STORE PROPERTY INVESTMENTS LTD

30th October 2015

Ref: A/131/15/RES – Land South of A259 and West of Mill Lane, Rustington; Parish of Angmering

drawing no: STORE18832 18L

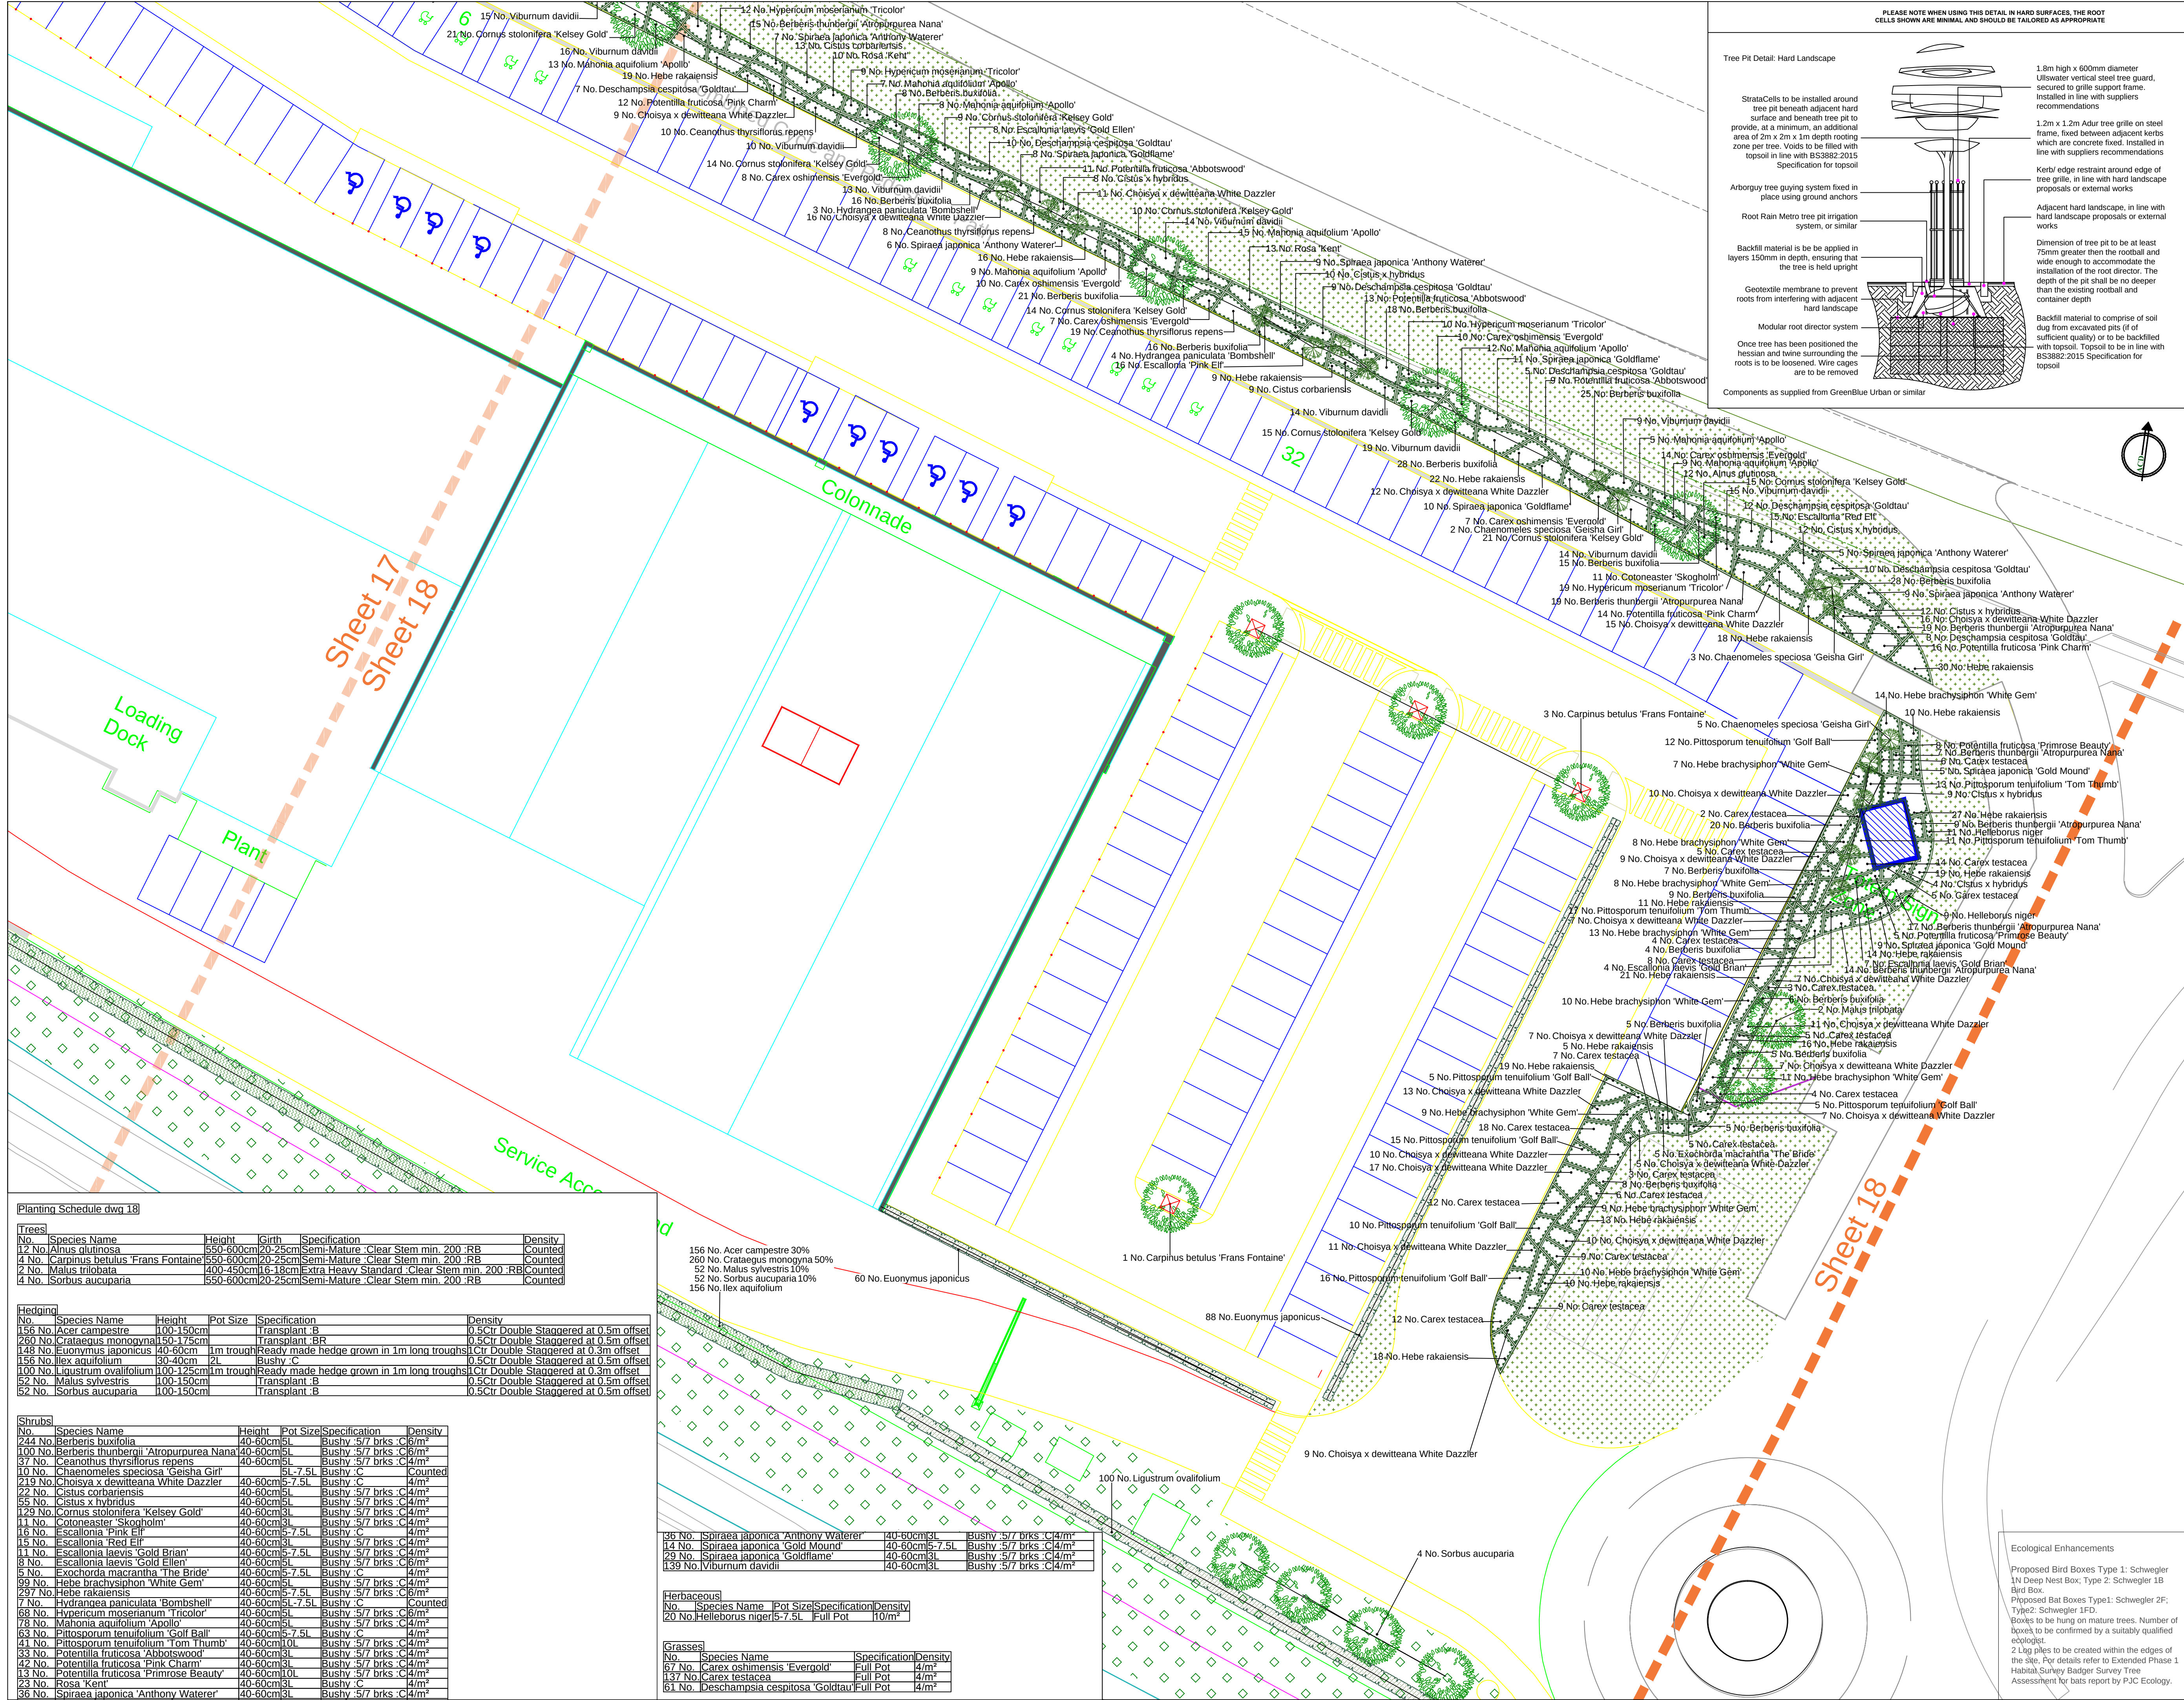
Along the road frontage with the A259, common alders (*Alnus glutinosa*) have been proposed as they provide an attractive frontage with a light and structured canopy. Angmering District Council have observed that we could provide more of these species along the western frontage of the A259 and also the Western boundary of the site, and having considered this further we agree and have consequently shown additional numbers of these species. This will result in a total of 10 *Alnus glutinosa* equally spaced along the road frontage with an additional 4 to be planted within the western landscaping area, providing a total of 14 of these species rather than 9 as originally proposed.

ADC parks and landscapes have expressed concern that the revised landscaping scheme is considerably more sparse particularly on the road frontage and rear areas. The introduction of the additional *Alnus glutinosa* will improve the road frontage and create an attractive frontage to the site.

We note that ADC are also concerned about the number of trees currently proposed overall and as such as well as the additional trees to the northern boundary, we have now significantly increased the number of proposed trees within the western planting area too. These will create an attractive and pleasant environment and additional wildlife habitat. The revised proposal will provide one new tree for each valued tree lost. Native species have been chosen for their biodiversity and wildlife value.
